OUT18/9251

**Bloomfield Colliery Life of Mine Extension - Modification 4 (MP 07_0087 MOD 4)
Comment on the Environmental Assessment**

Figure 13. Wallis Creek Water Source Alluvial Take

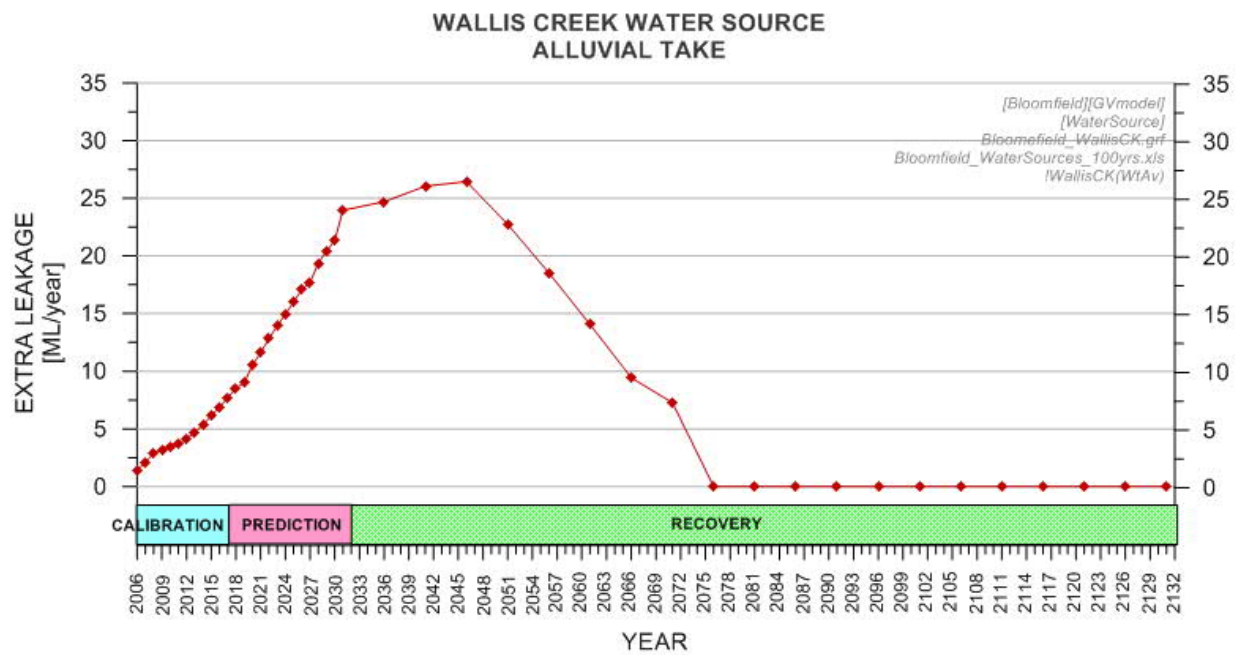
The department advises that a licence is required to offset each of the impacted water sources with an entitlement equivalent to the predicted losses or impact. Bloomfield Colliery does not hold licences for the peak predicted incidental take/loss of water from the alluvial aquifers associated with both the Wallis Creek Water Source and Newcastle Water Source. The alluvial aquifer system within the Newcastle Water Source sits below the tidal limit and does not form part of the Water Sharing Plan for the Hunter Unregulated and Alluvial Water Sources. Hence the proponent would need to obtain a groundwater licence under Water Act 1912 to account for the take from this water source.
